**Application for Planning Permission for Works or Extension to a Dwelling**

**Development:** Demolish existing single storey extension and detached garage.  
New single storey side extension.

**Location:** 38 Nyewood Lane Bognor Regis PO21 2SJ

BLOCK PLAN 1:500

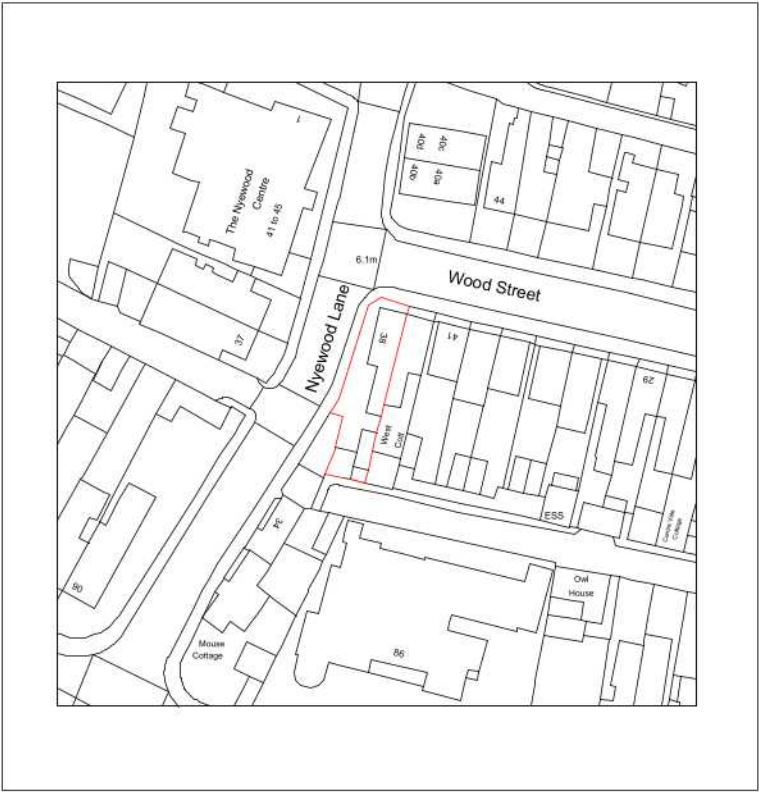
Dimensions: You are required to include dimensions on the block plan from the proposed extension(s) to ALL site boundaries. Please amend.
